Ribble Valley Borough Council
Development Control

Application: 3/2020/1073
Application Dove Syke Nursery Eaves Hall Lane
Proposal: C/use Agricultural land and building to pre-school forest school

6209 - P01 REV -

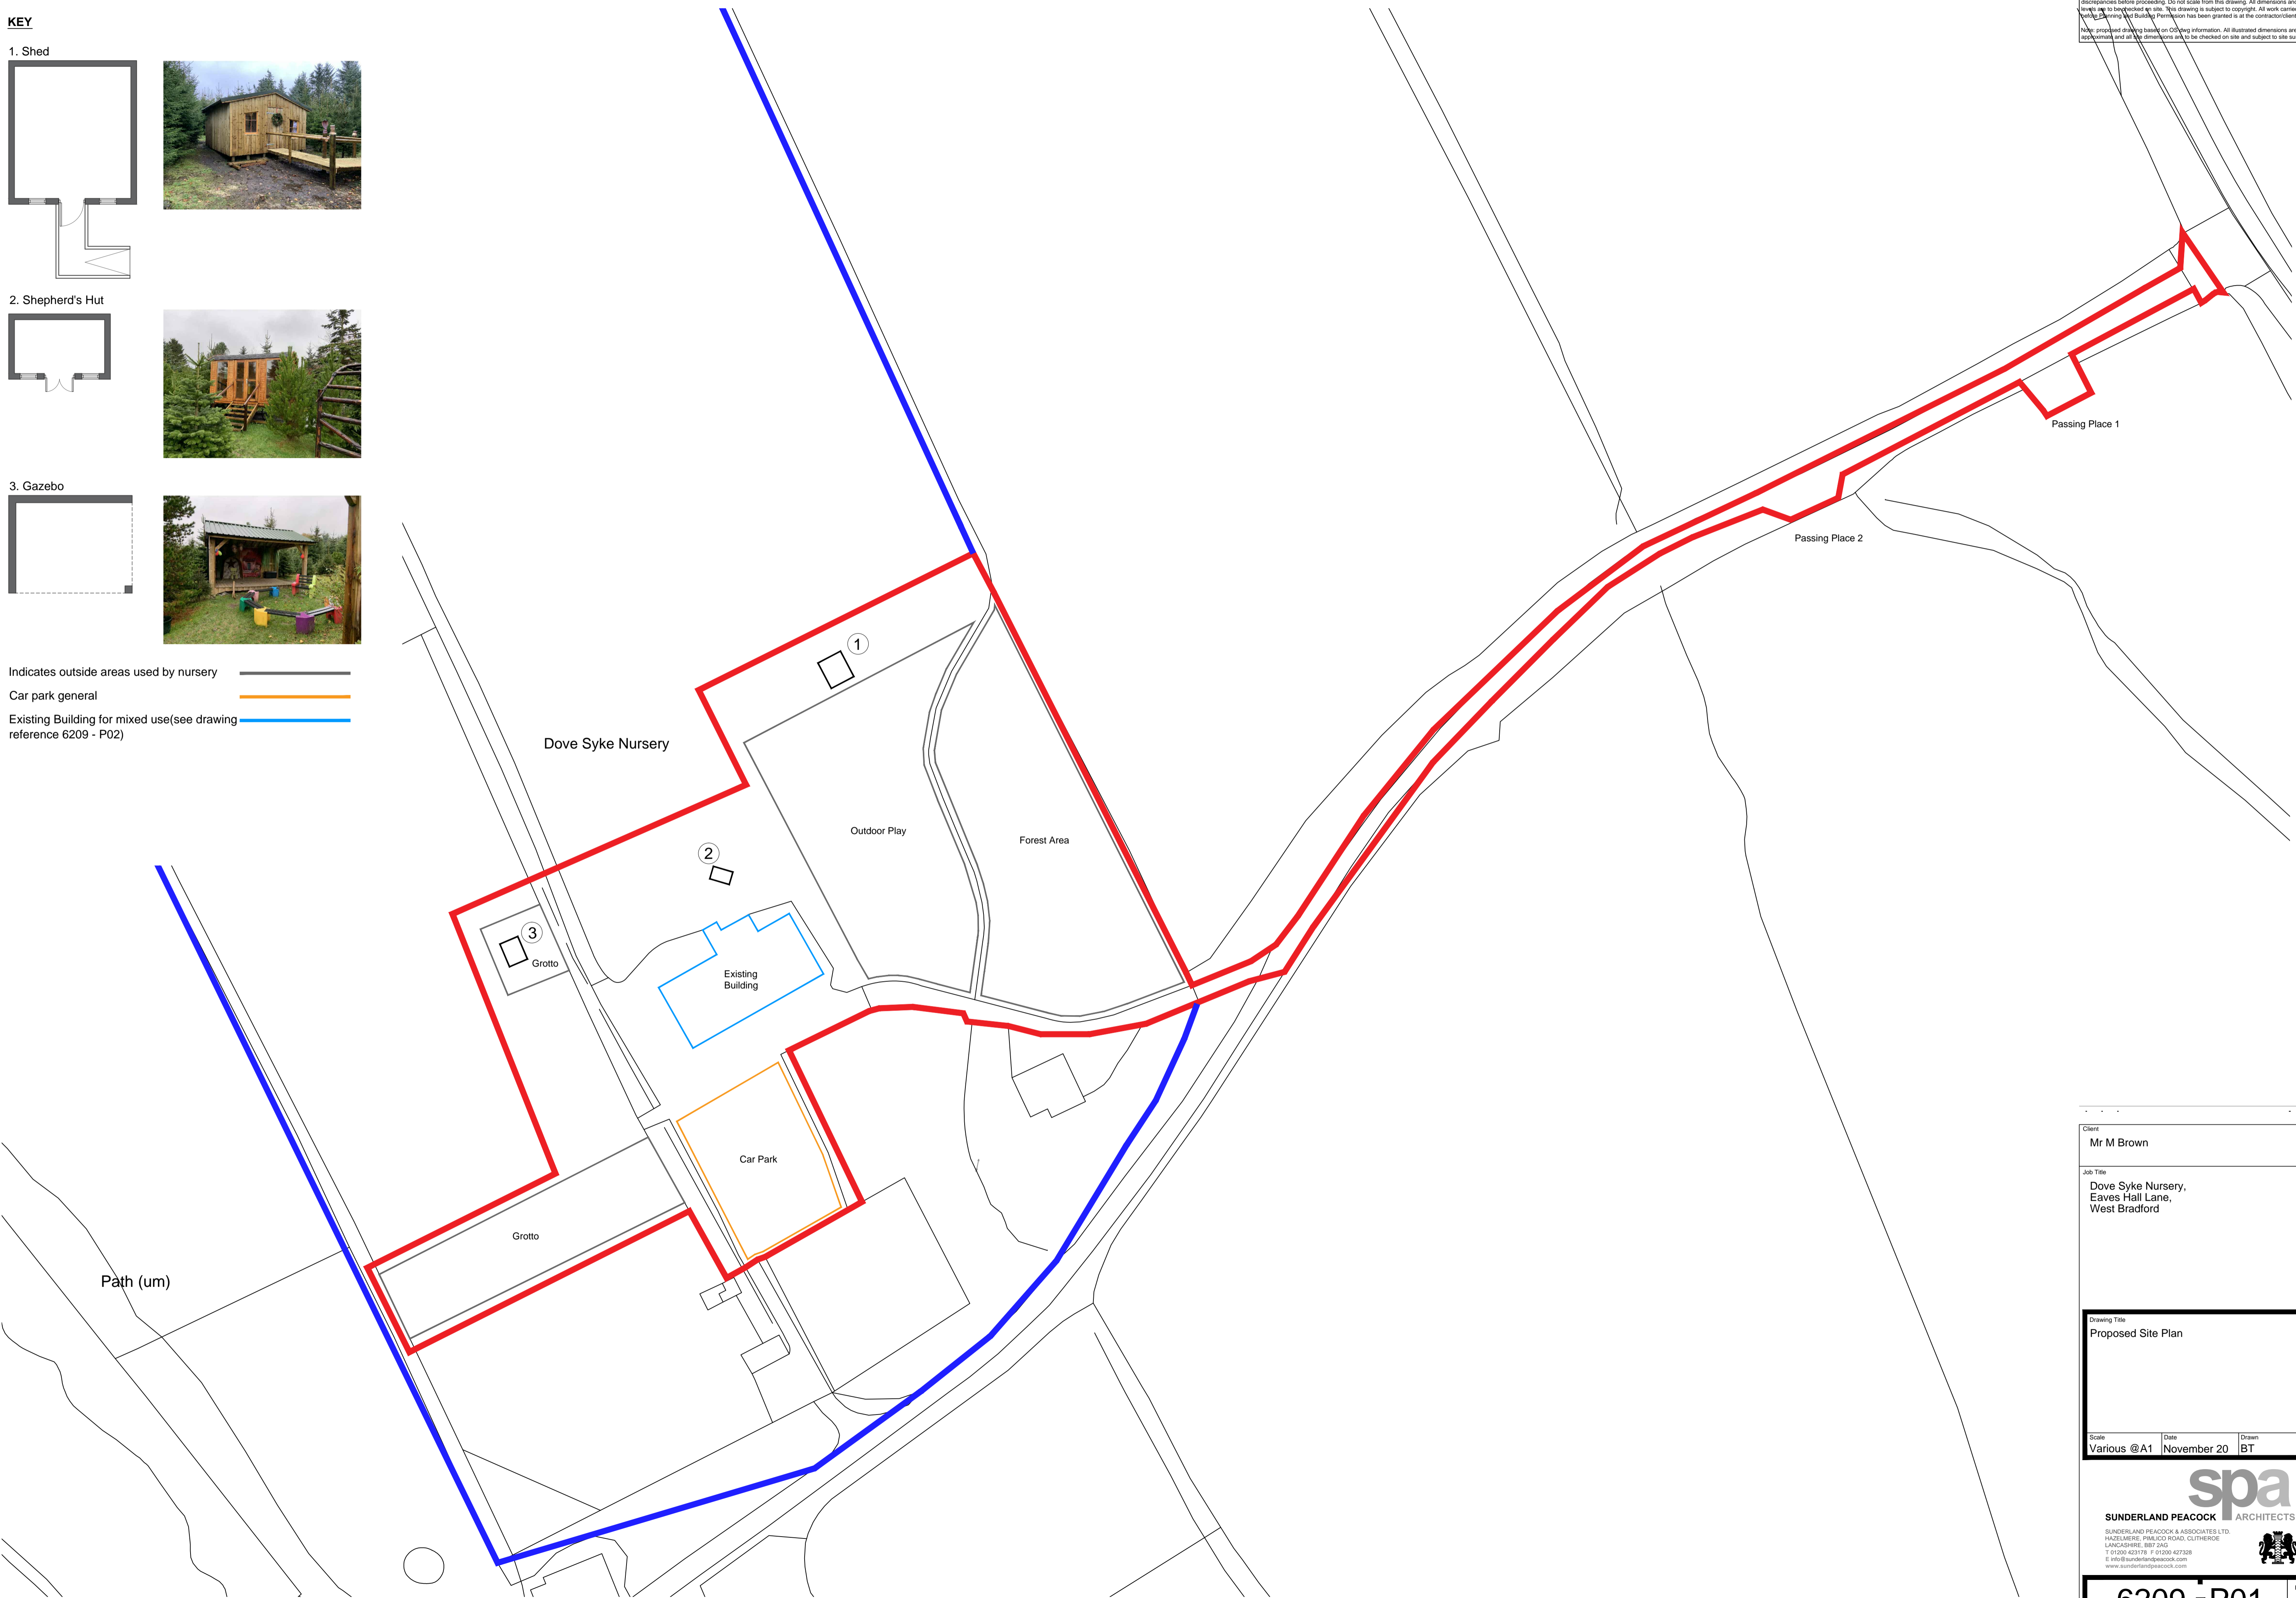
However, looking at the access from Eaves Hall Lane, the access would benefit from being widened at the junction to allow 2 opposing vehicles to pass. It is unclear from the submitted plan whether the applicant is in control of the land either side of the access to permit the local widening of the lane. If this is the case then this would be considered of benefit to the parents arriving at the nursery and should therefore be considered.
